Recommendation Report for Planning Permission for Works or Extension to a Dwelling

REF NO: FP/74/19/HH

LOCATION: 8 Ferring Gardens
Felpham
PO22 8HW

PROPOSAL: Single storey extension to existing conservatory and replacement of existing conservatory roof.

Ground Floor

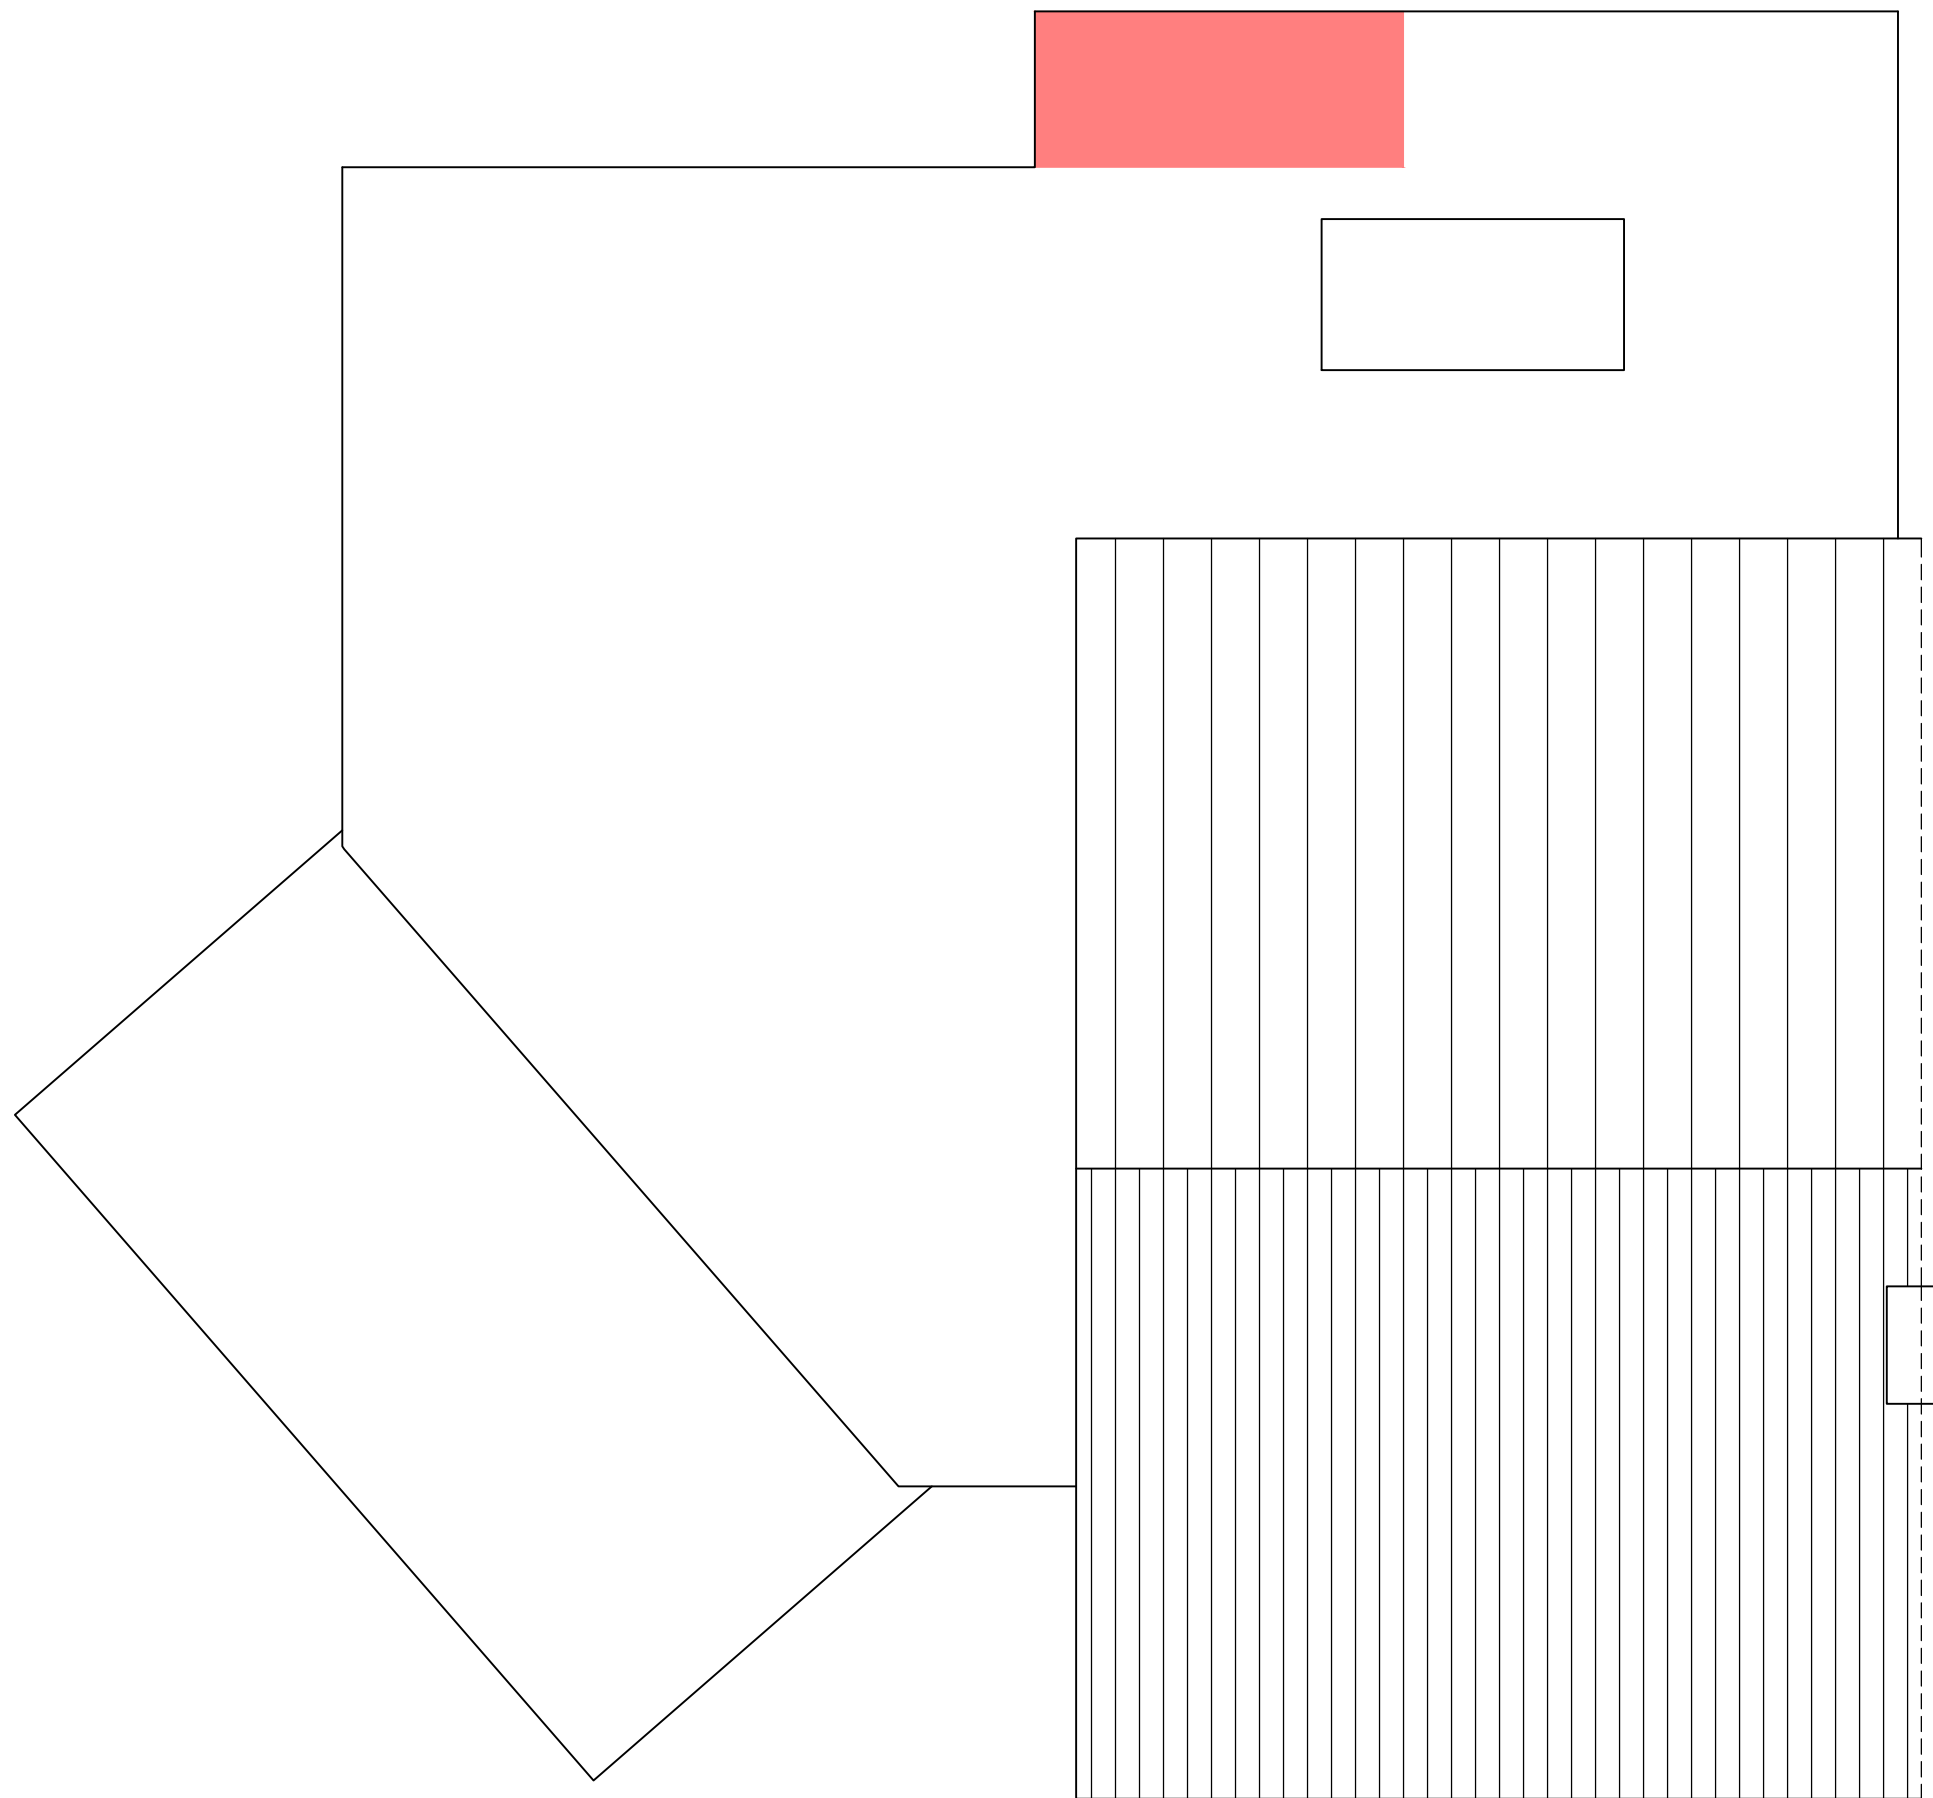
The extension is sited to the rear of the property and as a result is not visible from the street scene or wider area. The extension appears subservient to the host dwelling and is modest in size increasing part of the existing extension by 1m in depth and 2.4m in width. Materials will match that of the existing dwelling.

There will be doors to the rear which replace existing and with the development at single storey it is not considered to give rise to any adverse overlooking upon neighbouring amenity with the depth of the extension only increasing by 1m.

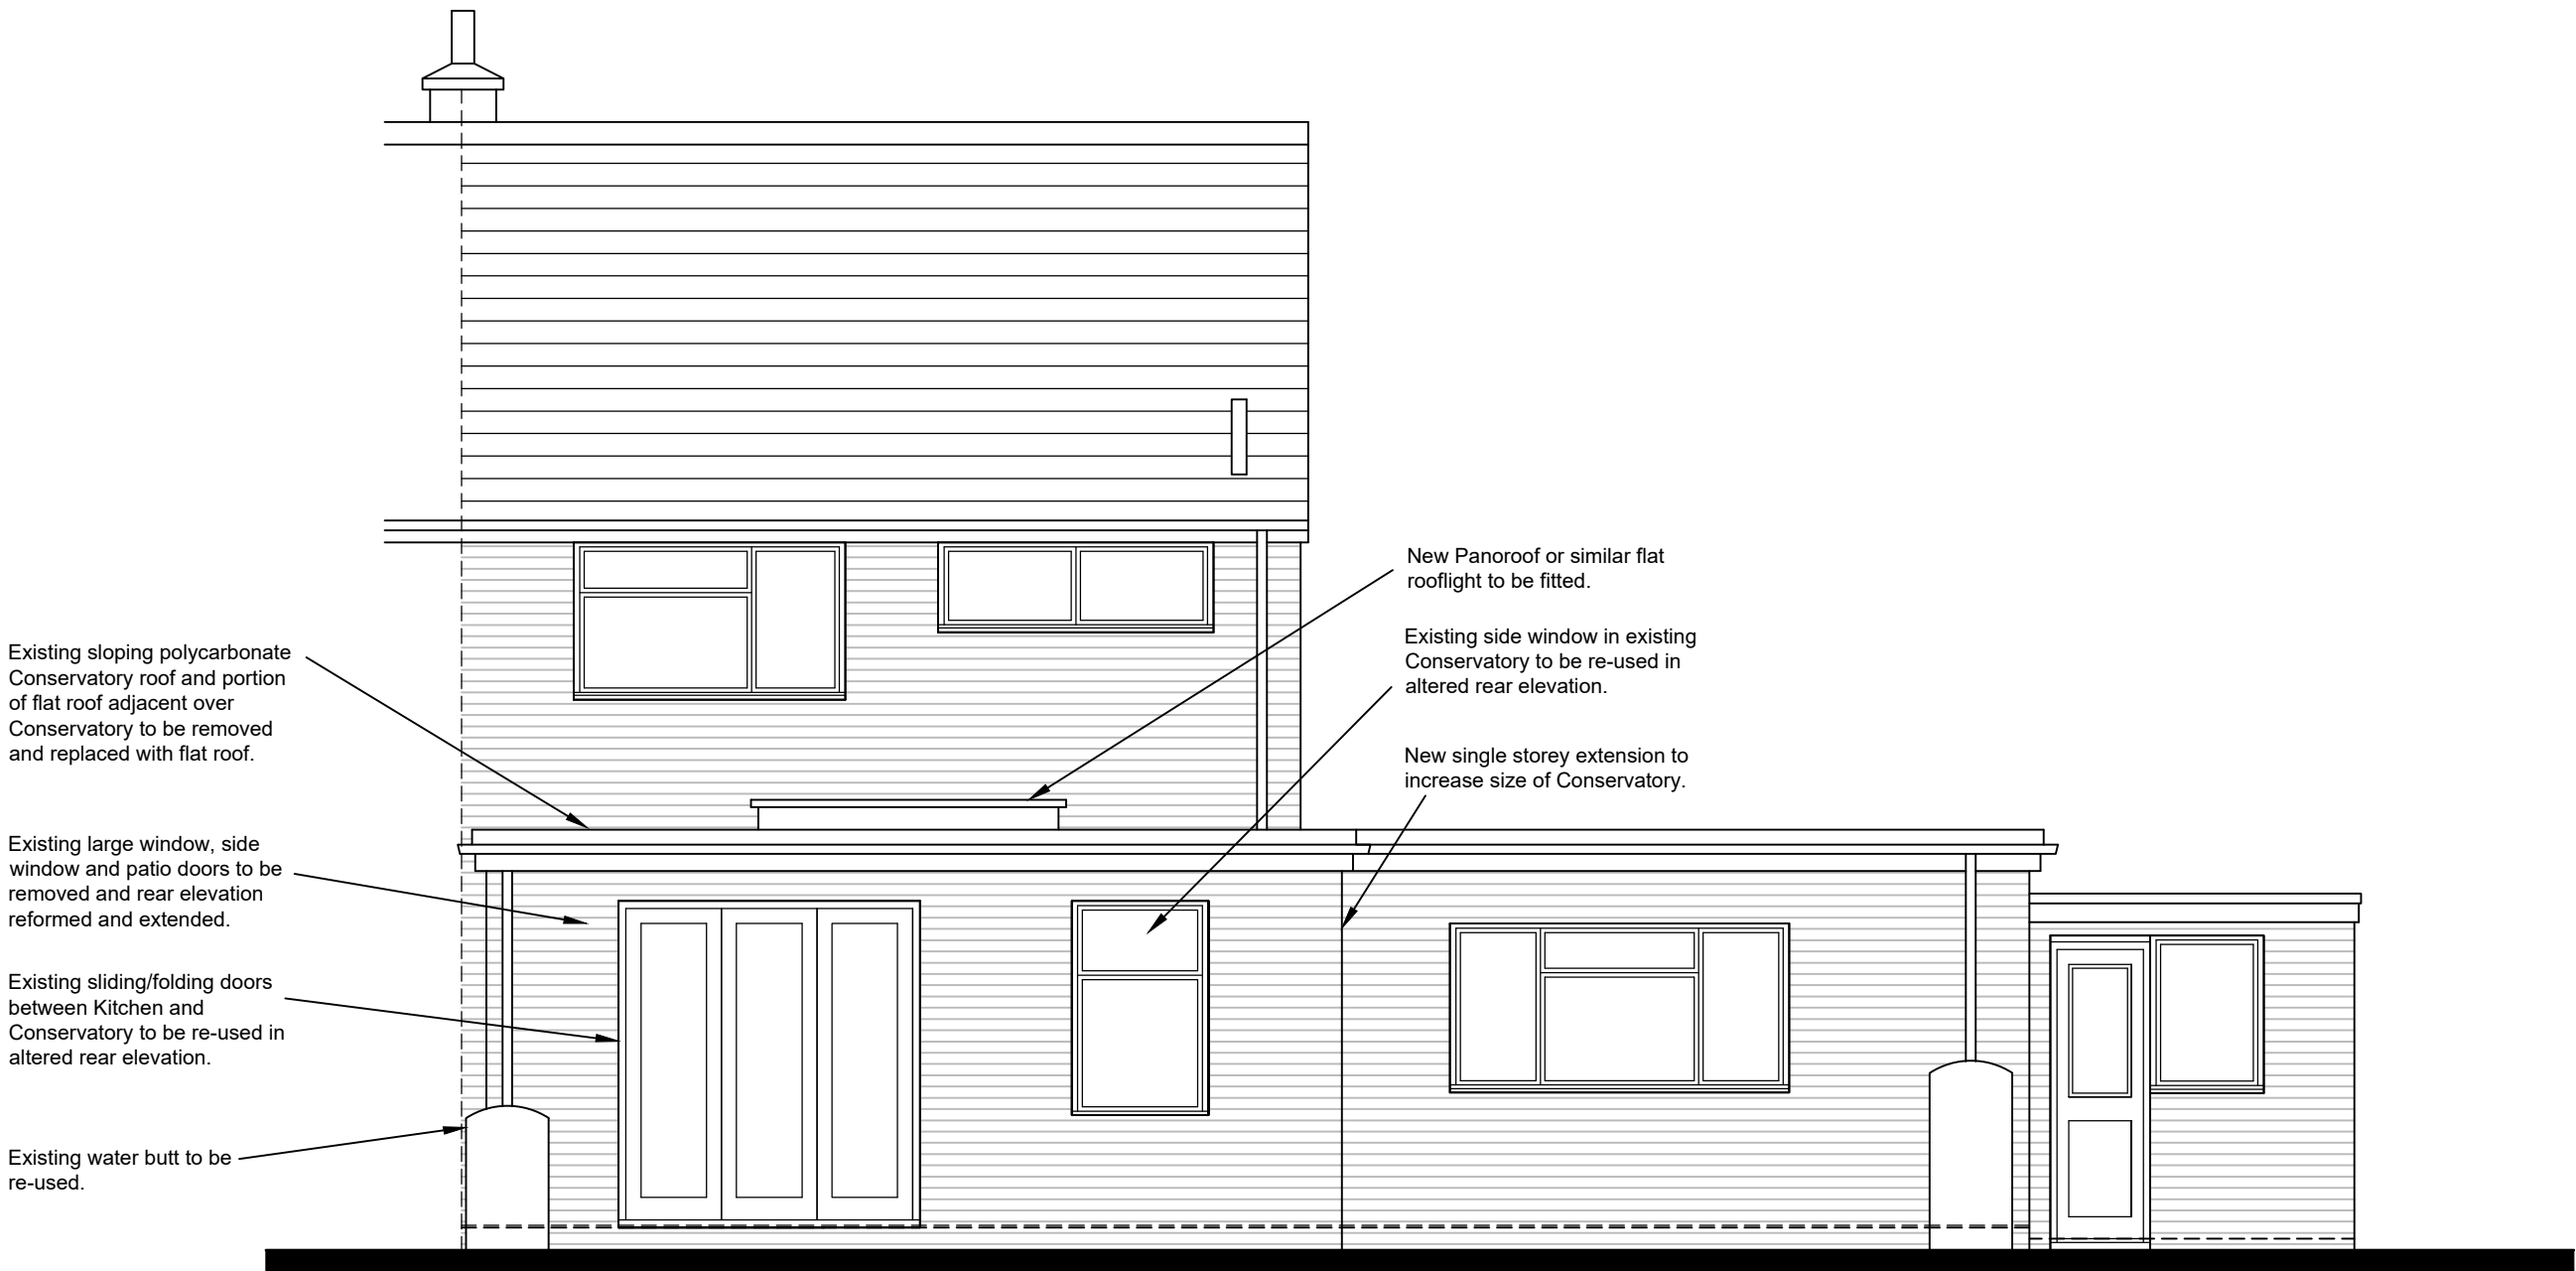
The proposed extension will be constructed to a maximum height of 3m with the addition of a roof lantern. The height will match that of the existing extension and conservatory roof which is also to be replaced which will create a more uniform appearance. Due to its siting it is not considered to appear adversely overbearing or overshadowing upon neighbouring amenity.
